From: Tim Uden [REDACTED]
Sent: 02 November 2018 12:16
To: Charlotte Bodin
Cc: [REDACTED]
Subject: Re: Planning application for Ilex Cottage (Ref: Y/82/18/HH)
Attachments: Certificate-B.pdf; Cert B covering letter .pdf; 2088.101A Location Plan .pdf; 2088.103A Block Plan .pdf; 2088.201C Car Port Proposals vwx v2014.pdf

- Location plan 2088.101A revised to show continuous red line around site.
- Block Plan 2088 103A revised to show note relating to dimensions to boundary.
- Proposed plans 2088.201C revised to show roof line which follows the line of the east garden wall, and dimensions to the boundary from roof.
- Copy completed Certificate of Ownership-Certificate B.
- Copy of letter sent to shared owner of the drive.

ROOF PLAN

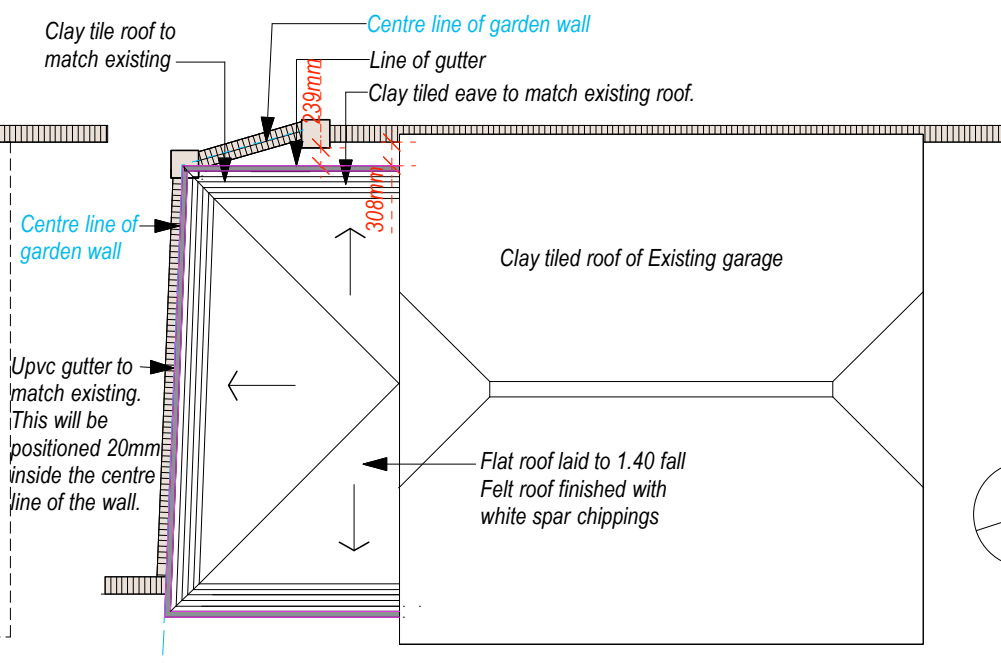
Regarding point 3, please annotate the dimension on the roof plan, rather than the block plan as stated in the letter, as this is the plan on which it can be shown most clearly.
